Planning and Highways Delegations Committee

Report Title: Sheringham Shoal and Dudgeon Offshore Windfarm Extension Projects - Submission Consultation

Date of Meeting: Wednesday 26 October 2022

The Sheringham Shoal Extension Project (SEP) and Dudgeon Extension Project (DEP) are Nationally Significant Infrastructure Projects (NSIPs). The developer, Equinor, have now submitted their Development Consent Order (DCO) application to the Planning Inspectorate (PINS). The proposal is to extend both the existing

Title:
Figure 3.3.1 Main Compound Alternatives
2. 1067 Fakenham Road, Attlebridge

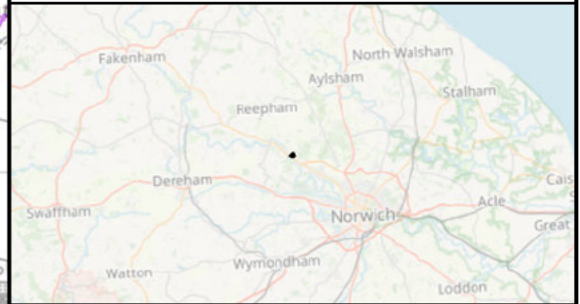
- The County Council supported the location of the main construction compound being at the greenfield site at Attleborough (A1067 Fakenham Road);
- The Lead Local Flood Authority required the applicant to consider surface water drainage issues at the main compound site;

- The Natural Environment team required a 10m stand-off between the compound and the trees to the southeast of the site.
- 3.7. The above comments have largely been positively considered and addressed by the applicant or will be addressed through on-going DCO process.
